Rezoning Transportation Analysis
Petition Number: Insert Zoning Petition #2021-046
General Location Identifier: 08705203

Revision Log:

Date	Description
04-29-2021	First Review (EL&KP)
05-27-2021	Second Review (EL)
06-30-2021	Third Review (KP)

RZ1.0

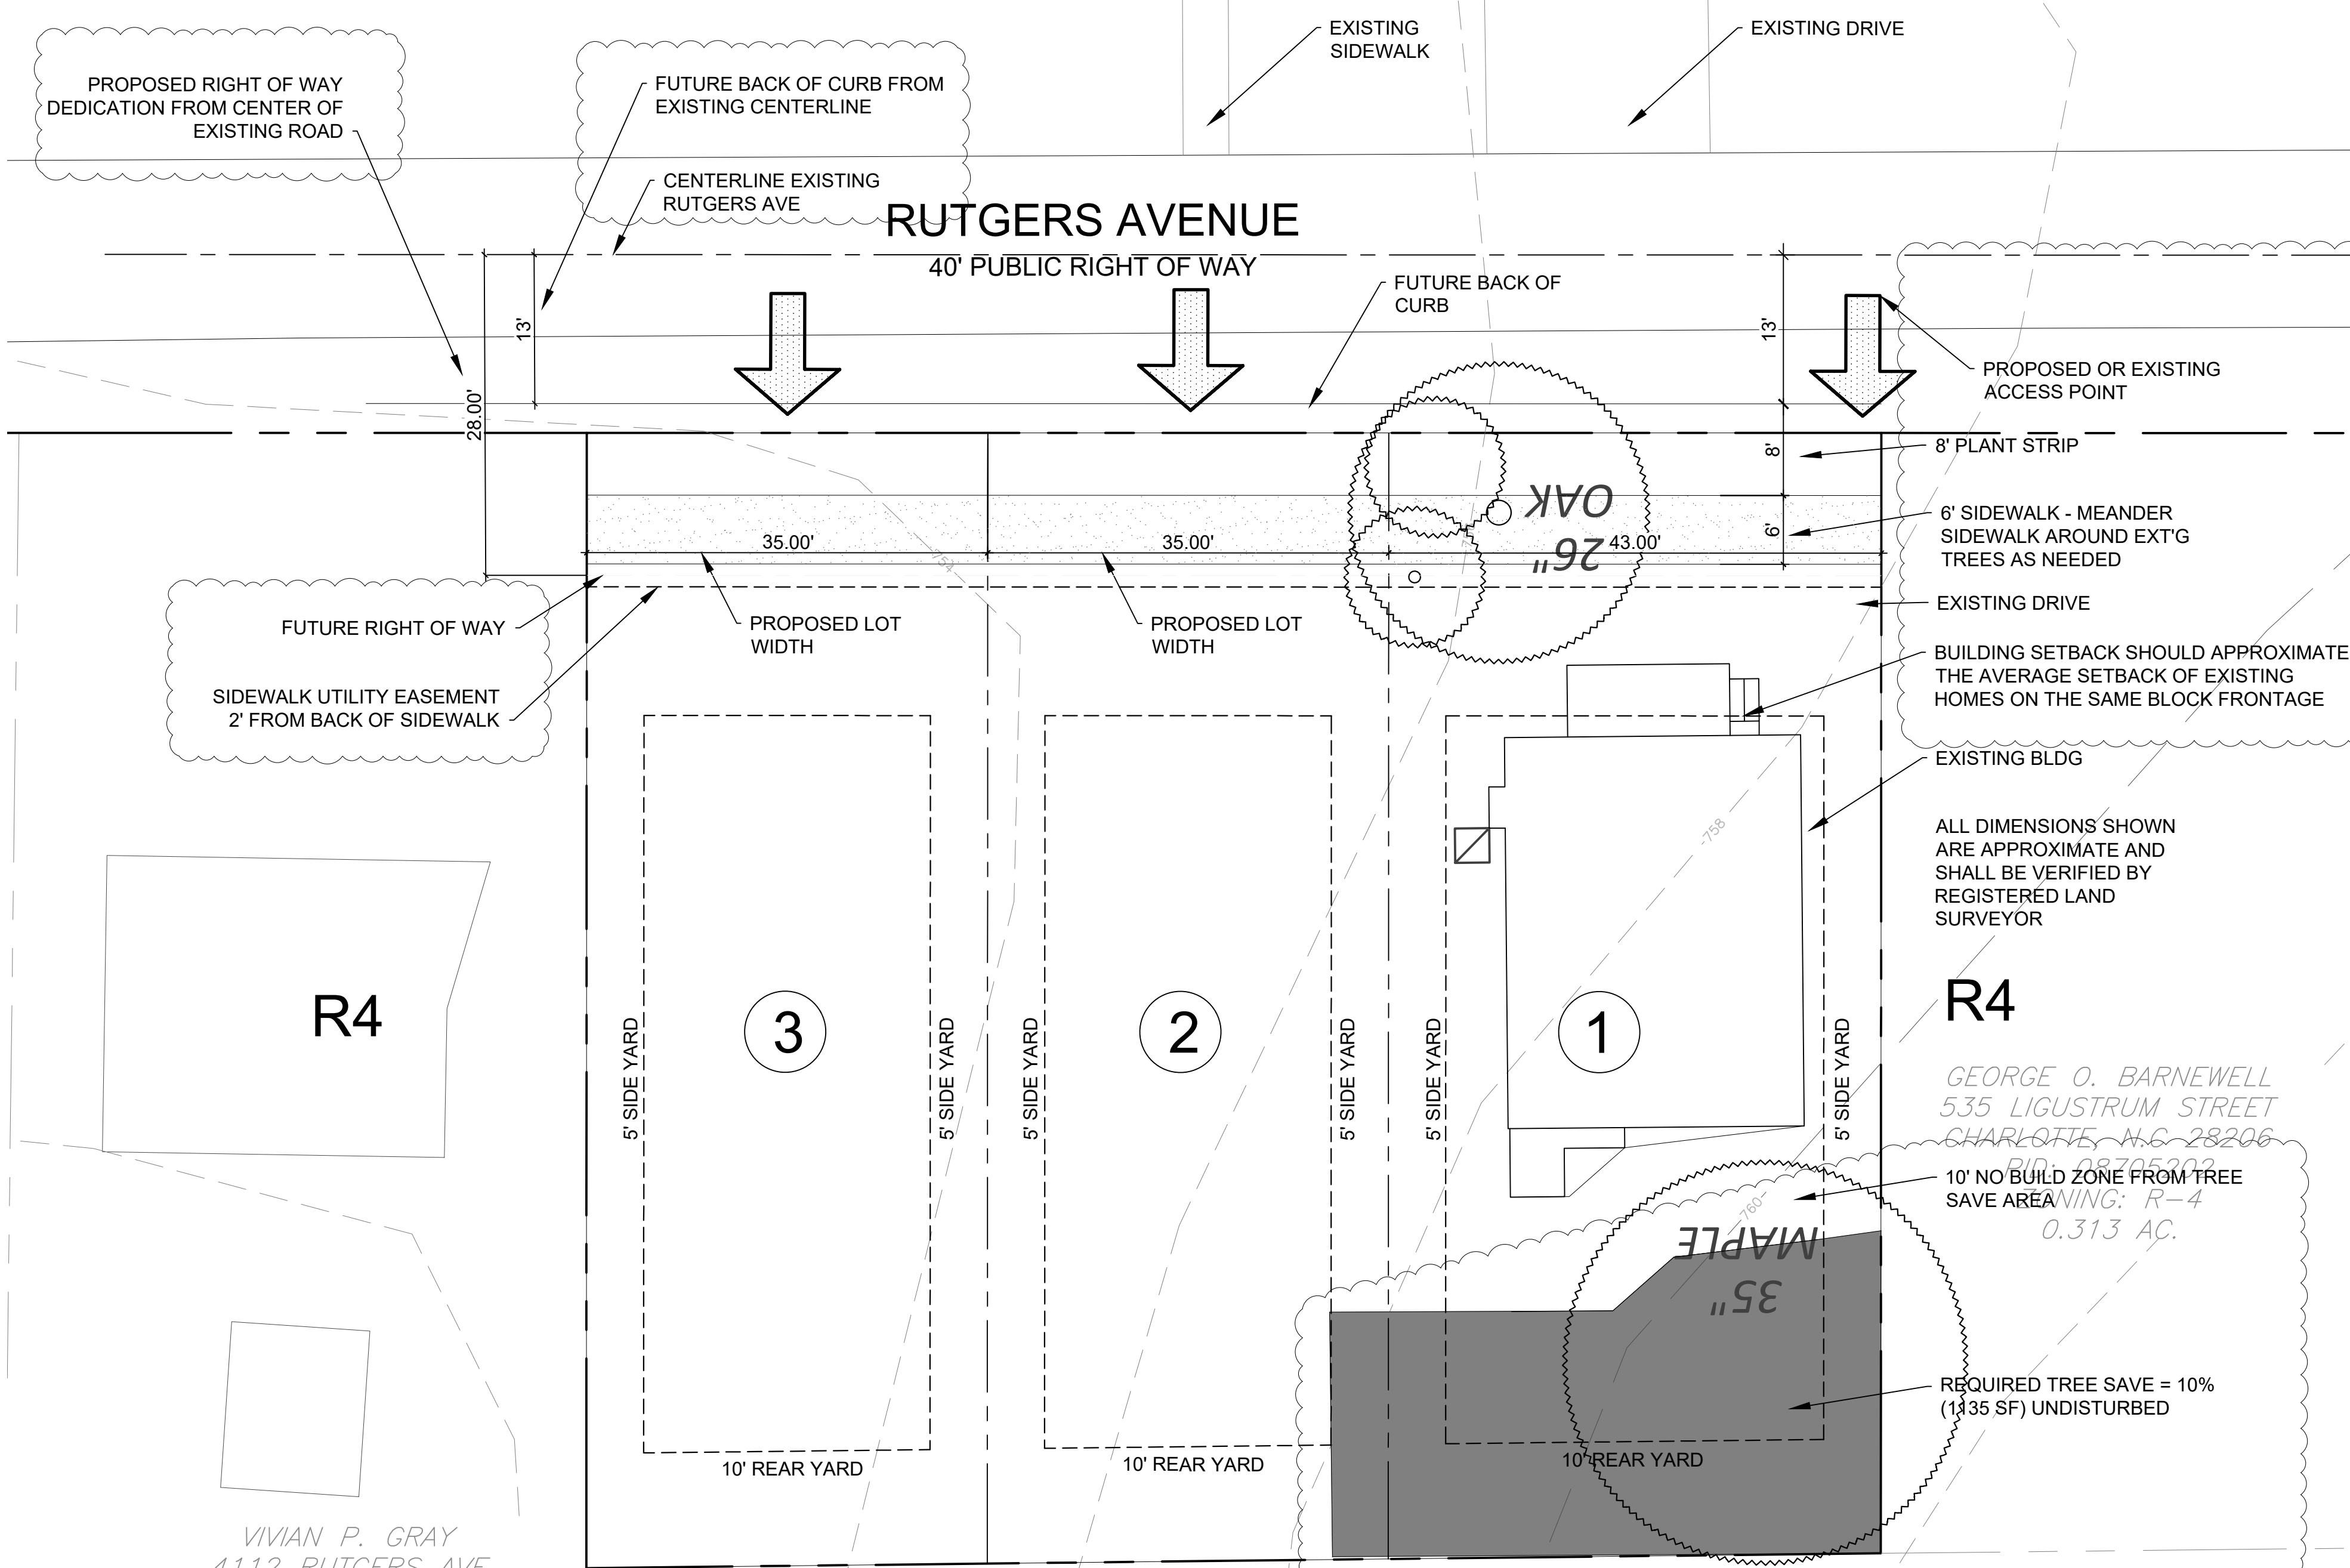
1. ~~**Curb line:** The proposed zoning district has a setback measured from back of the existing or proposed future curb line.~~
 - a. ~~**Rutgers Avenue:** The future location of curb and gutter will be located 13 feet from the existing centerline to back of curb.~~

~~Label and dimension the curb and gutter from the centerline.~~

3. ~~Revise site plan and conditional notes to commit to dedicate 28 feet of right-of-way from the Rutgers Avenue centerline. The site plan shall label and dimension the right-of-way from the road centerline.~~

4. ~~Revise site plan and conditional note(s) to commit to construct an 8 foot planting strip, and 6 foot sidewalk along the site's Rutgers Avenue frontage, per Chapter 19. The site plan shall label and dimension both items from the road centerline.~~

5. ~~Revise conditional note C.2 to "The site will be served by private driveways, as generally depicted on the rezoning plan. Minor adjustments to the driveway locations will be permitted, subject to CDOT approval during the permitting process."~~

6. ~~Revise site plan by showing the driveway and sidewalk associated with PID 08705403 on the opposing side of Rutgers Avenue.~~

The site is located on Rutgers Avenue, a City-maintained local street that stems off Sugar Creek Road. The petitioner has committed to providing an 8-foot planting strip, 6-foot sidewalk, and right-of-way dedication along the rezoning site frontage, in accordance with City Ordinances. All CDOT items are addressed.
